BUILDING CODE OF AUSTRALIA REPORT

**Warehouse Facility & Distribution Centre for
Martin Brower
Proposed Lots 5 & 6, Corner of Horsley Drive
& Cowpasture Road, Horsley Park**

As Accredited Certifiers, we have reviewed architectural design documents prepared by Australand (refer appendix A) for compliance with the Building Code of Australia 2015.

DRAWING NUMBER MB-WSPT-DA-003
 ISSUE B

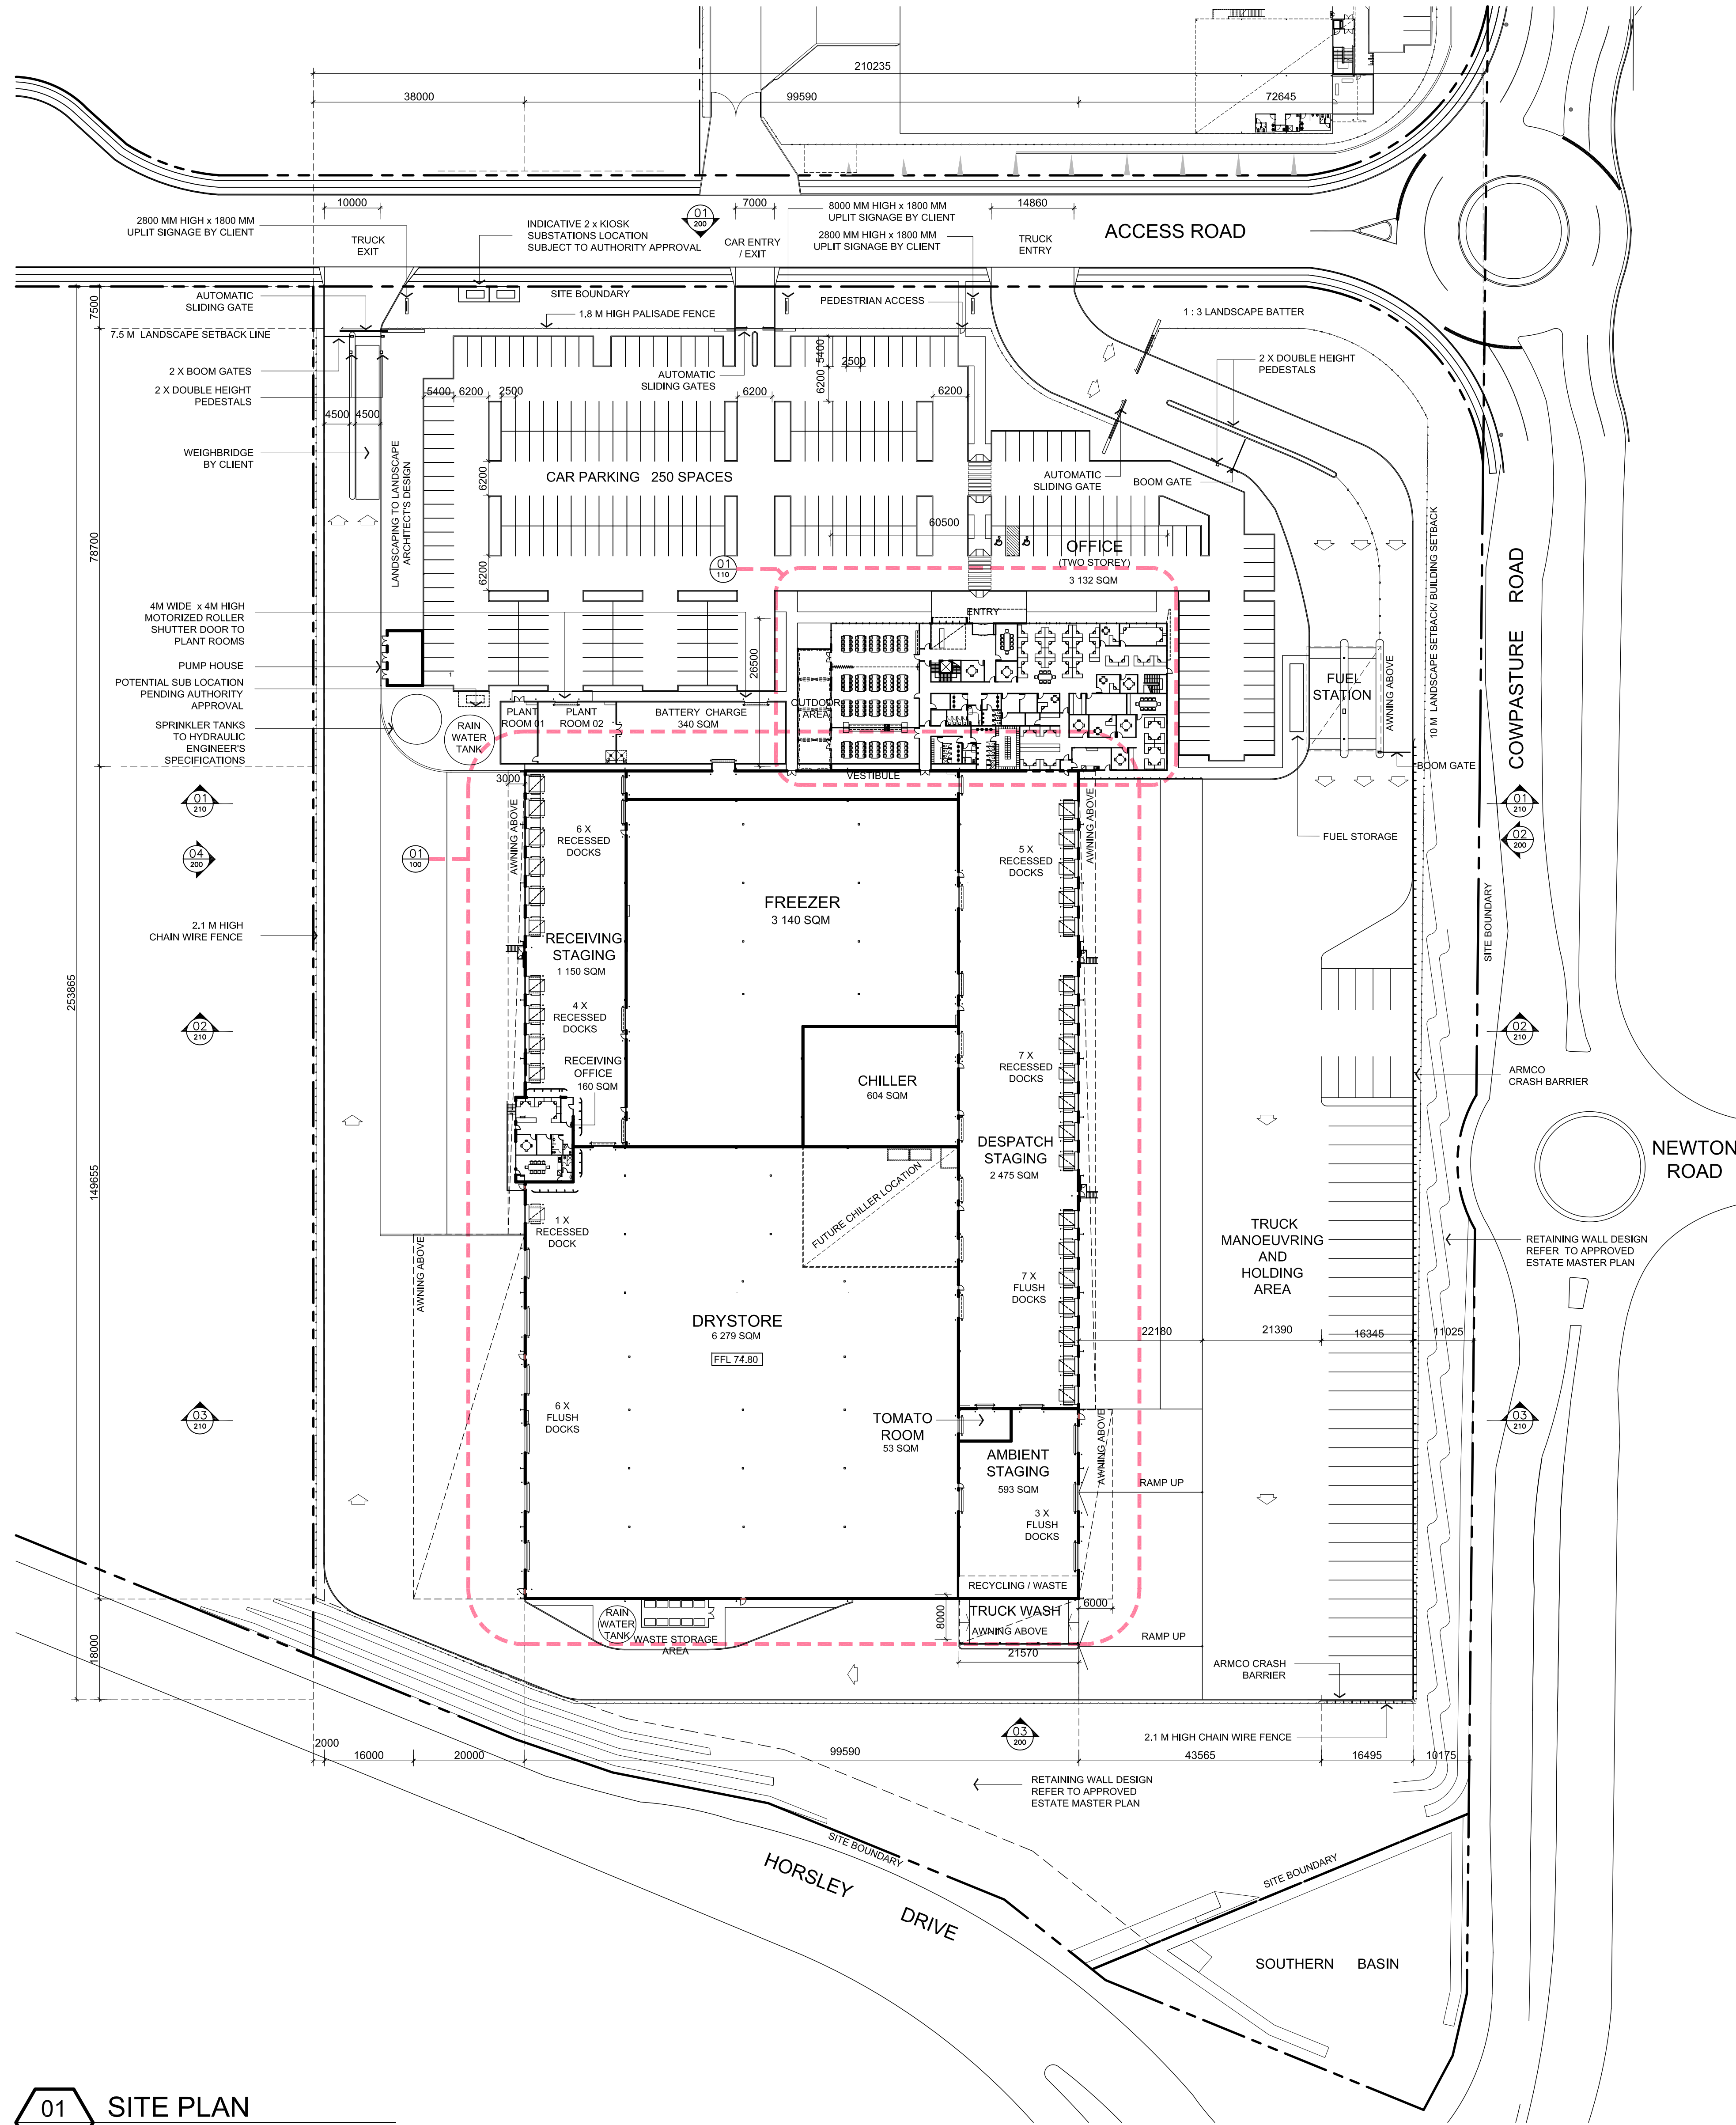
DTS Clause	Description of Non-Compliance	Performance Requirement
C2.4	Perimeter Vehicular Access Compliant perimeter vehicle access has not been provided to the Northern perimeter of the building.	CP9
D1.4 & D1.5	Travel Distances <u>Office</u> Travel distances of up to 25m to a Point of Choice and 55m to an Exit <u>Warehouse</u> Travel distances of up to 30m to a Point of Choice, 100m to an Exit and 120m between alternative Exits	DP4 & EP2.2
D1.10	Discharge of Exits Discharge of exits must be open directly to the sky, currently awnings are located above some Exits.	DP4
E1.3	Fire Hydrants If fire hydrants are located underneath awnings and/or if the location of the booster does not meet the prescriptive provisions these will be required to be included as part of the fire safety engineering.	EP1.3
E2.2	Smoke Hazard Management System The Smoke Hazard Management provisions within the facility shall be assessed as part of the fire safety engineering.	EP2.2

- i. Continuous access for a 6.0m wide access roadway with no part further than 18m from the building has not been provided in a forward direction to the North Elevation due to the truck entry and driveway being located greater than 12m from the building line. It is also noted that water tanks to the North-West Elevation also obstruct the vehicle access.
- ii. Vehicle access has potentially been obstructed to the West Elevation due to an awning. Where the clear height of the awning is less than 4.5m it will be required to be included in the fire engineering.
- iii. Vehicle access to the Truck Exit is approx. 4.5m wide per lane in lieu of 6.0m unobstructed width.

01 RECEIVING OFFICE FLOOR PLAN
 1:100 @ B1

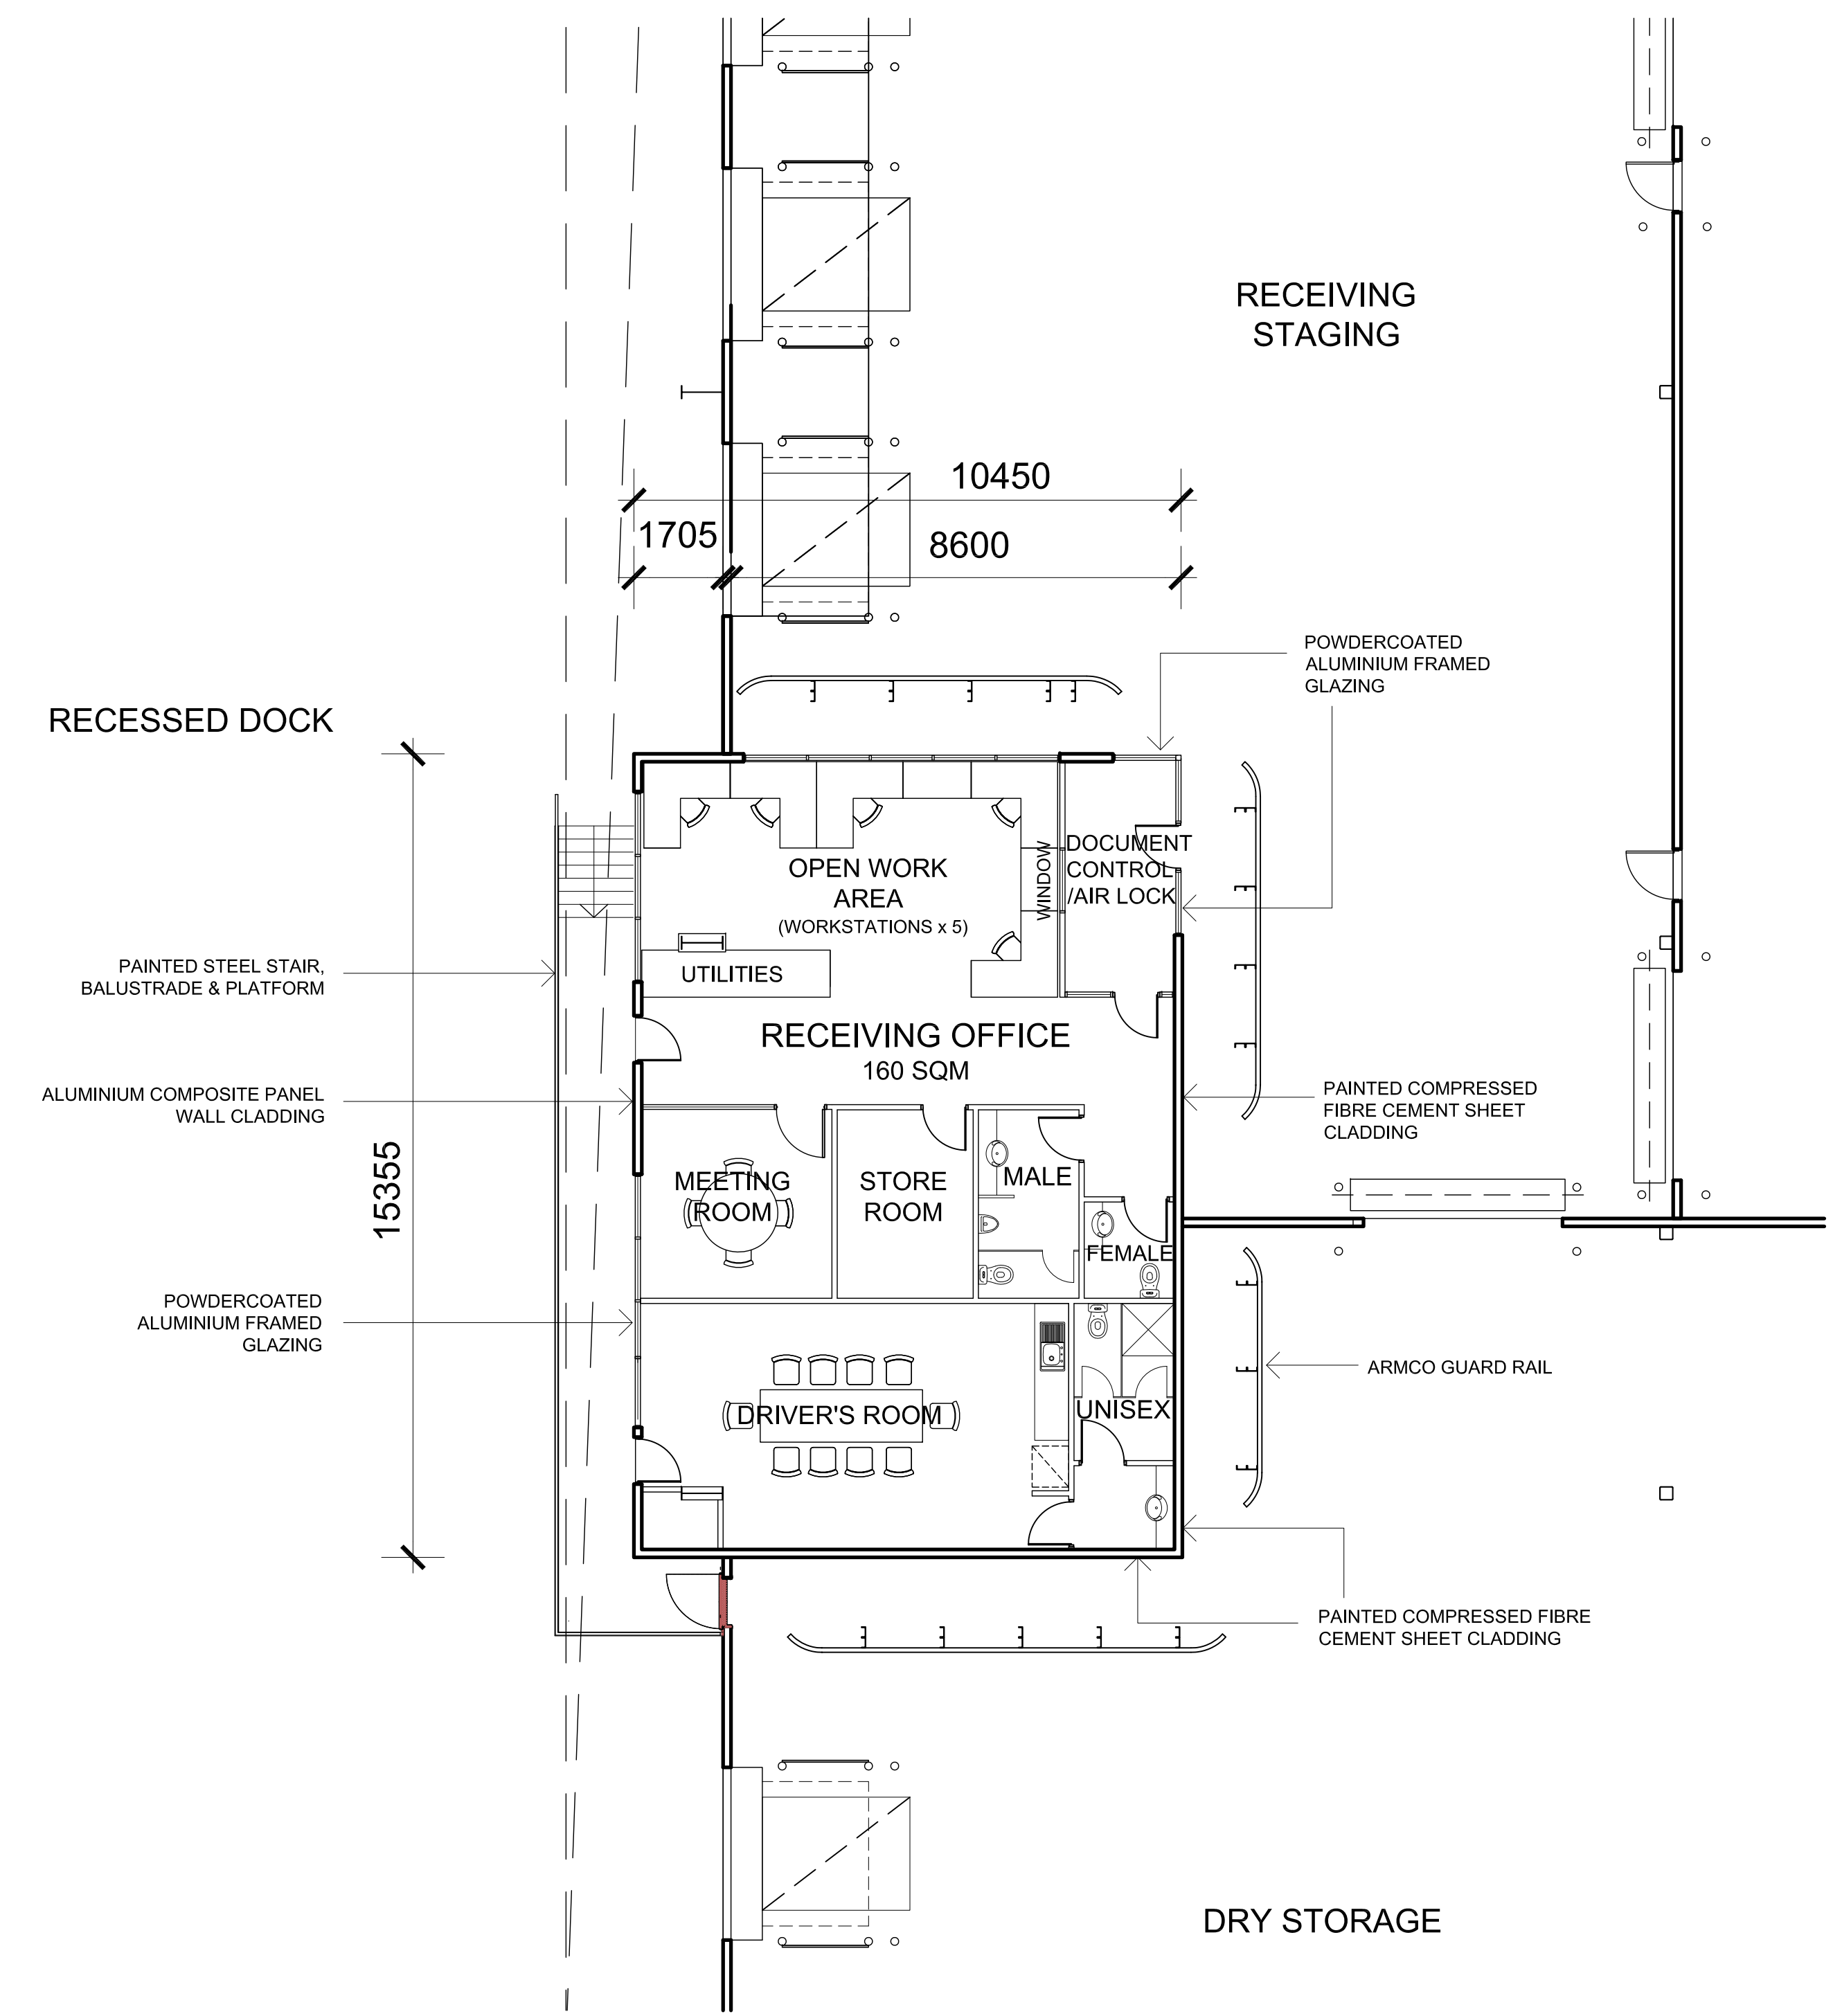
BCA Clause	Comment
C2.12	Details for the intended use and capacity of the battery room are to be provided. Dangerous Goods Consultant is also required to confirm additional requirements.
Part D3 & AS1428.1-2009	Provisions for Wheelchair access will be required to be provided to the Receiving Dock Office.
D2.19/D2.21	Vertical sliding (forklift) doors located on a path of travel to an Exit will be required to be provided with fail safe opening devices or alternatively additional breakout doors may be located between rooms.
F2.3	Details for ambulant facilities are to be provided.
